WELWYN HATFIELD COUNCIL – DEVELOPMENT CONTROL
DELEGATED REPORT

APPLICATION No:	S6/2010/0094/LB
------------------------	------------------------

‘Replacement of corrugated asbestos cement roofing with lead sheet incorporating rooflights removal of redundant internal walls and raising level of part of floor. insertion of new french doors and sliding-folding doors into external walls.’

DRWG No 797.05

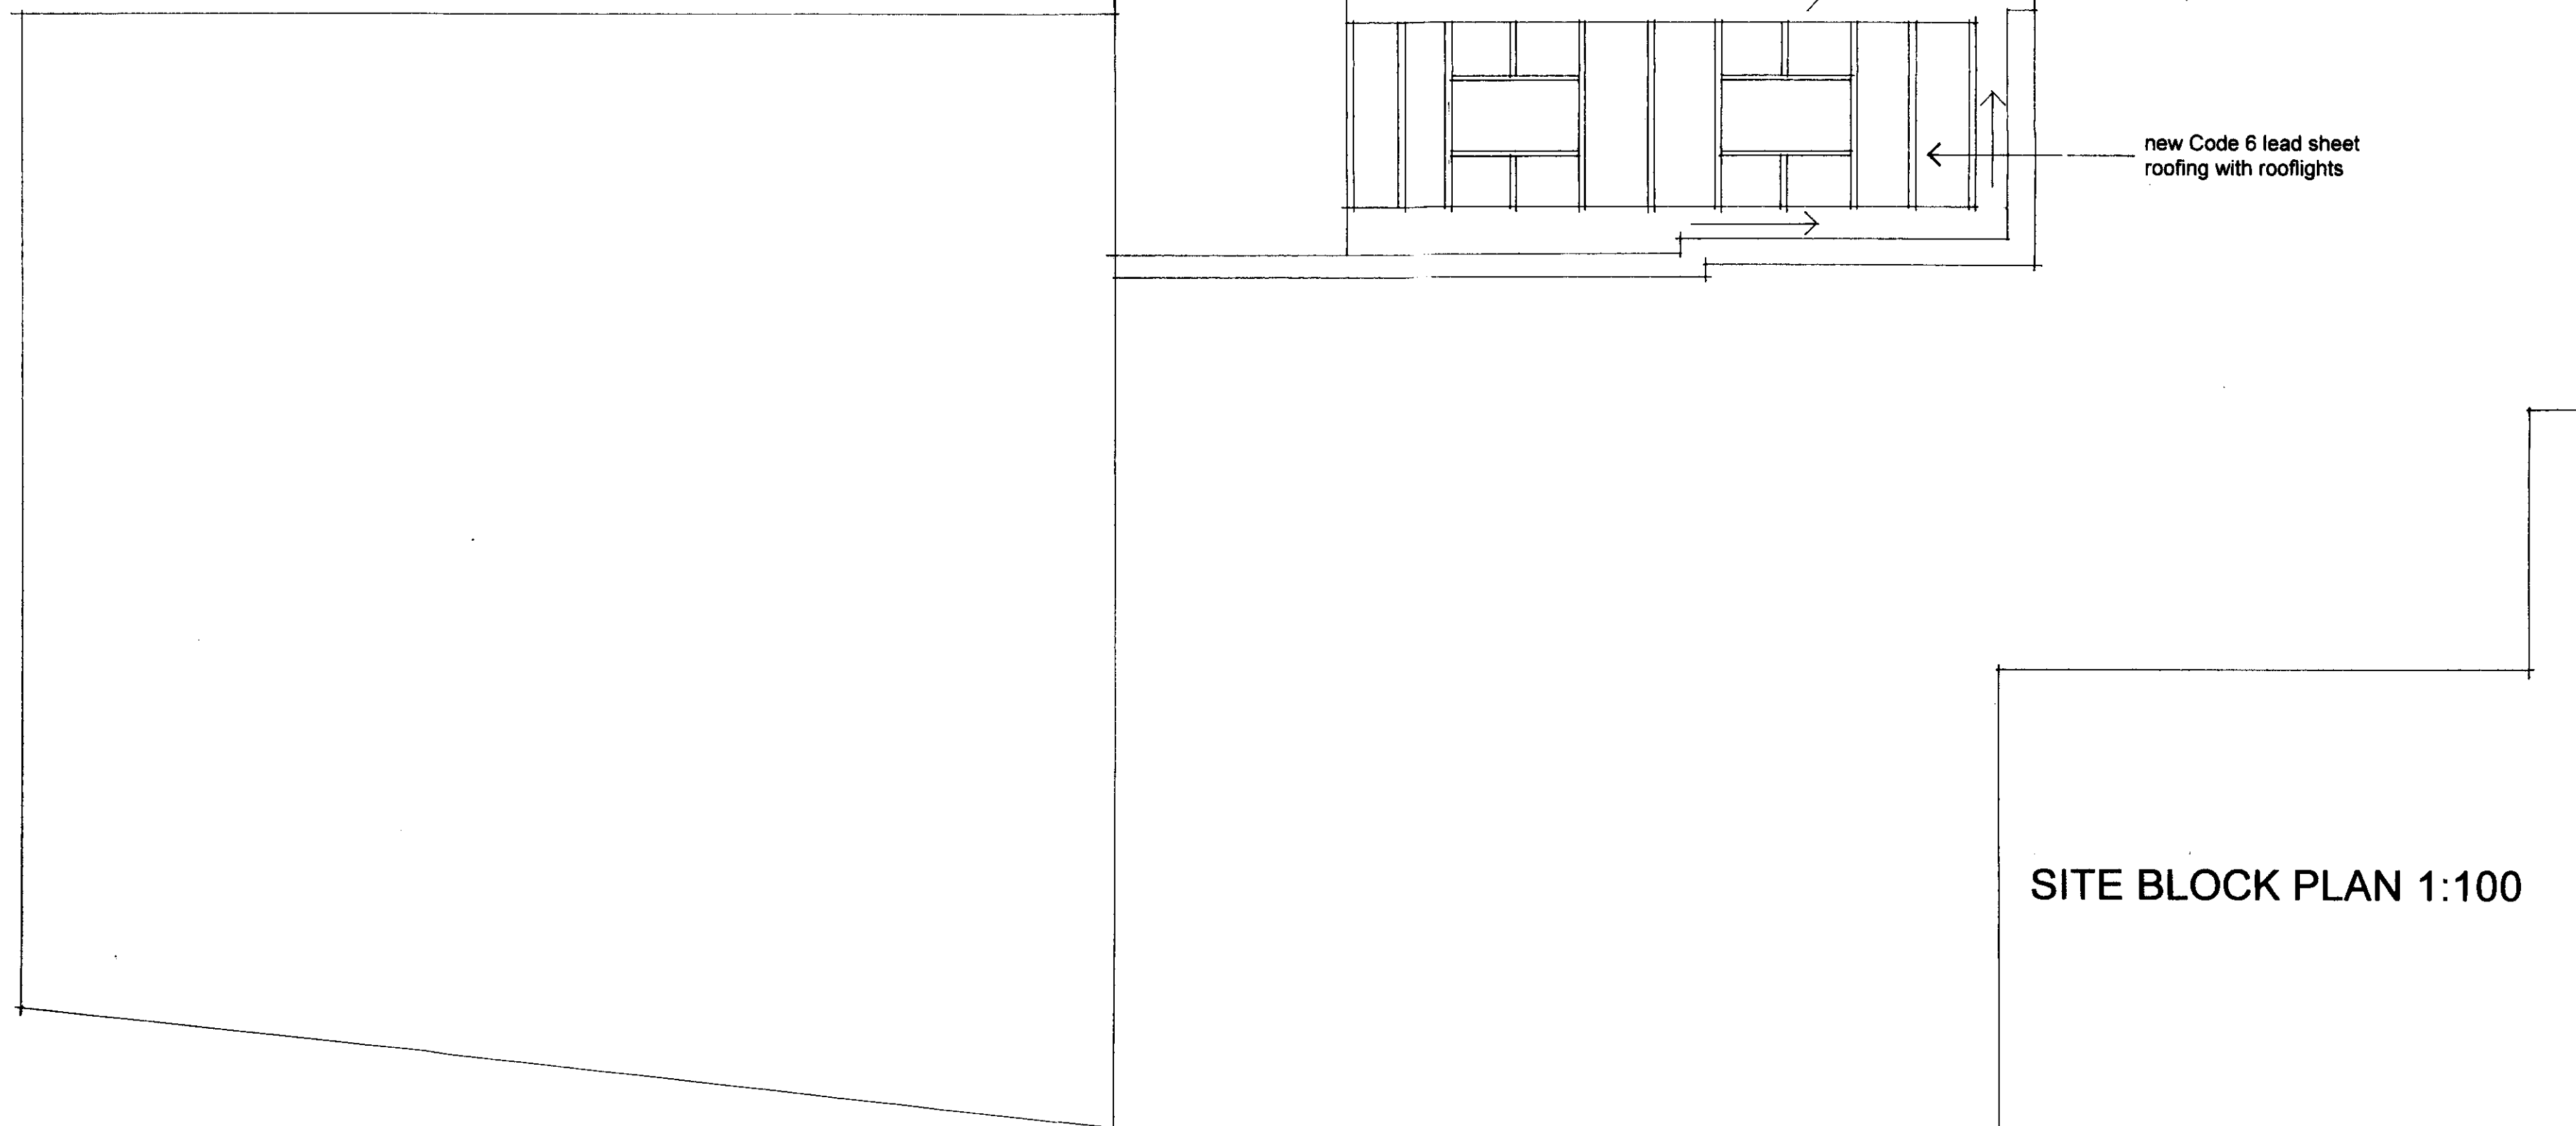
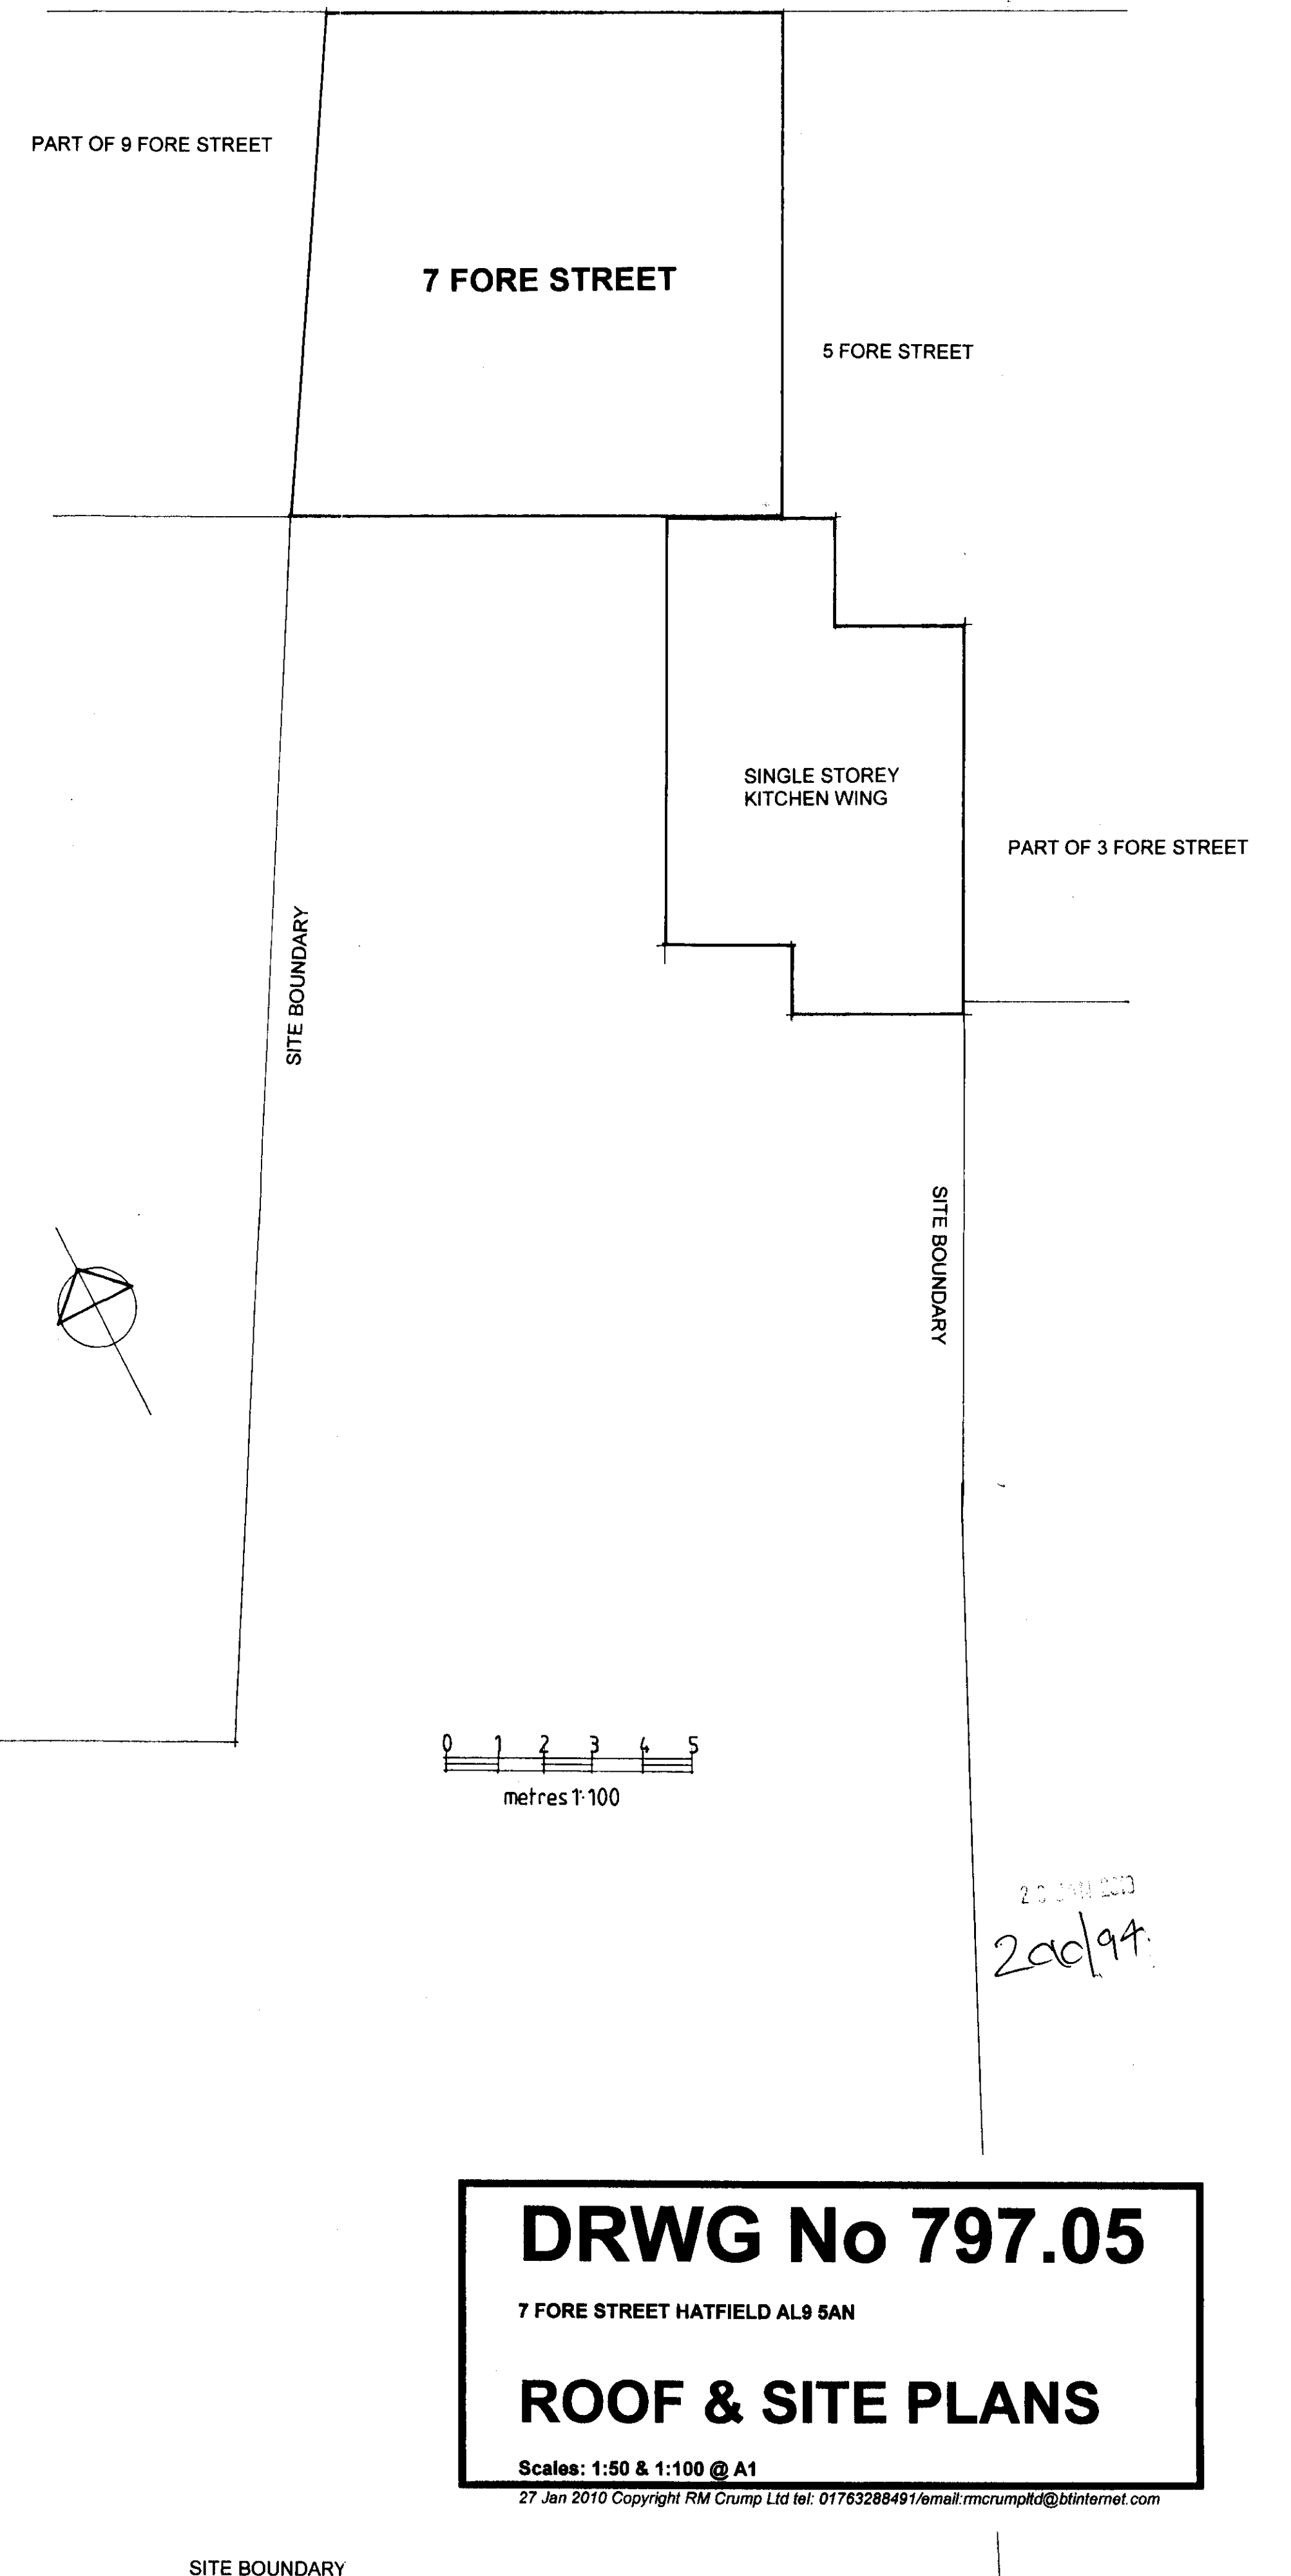
- 1.) The existing roof is of a poor quality and is only visible from the upper windows of the application property as it is concealed behind a brick parapet wall. The proposed use of code 6 lead roof with rooflights would be a significant improvement over the existing structure as it is not readily visible, there are no other issues raised with this proposal, subject to it being constructed to the details shown on approved drawing 797.04
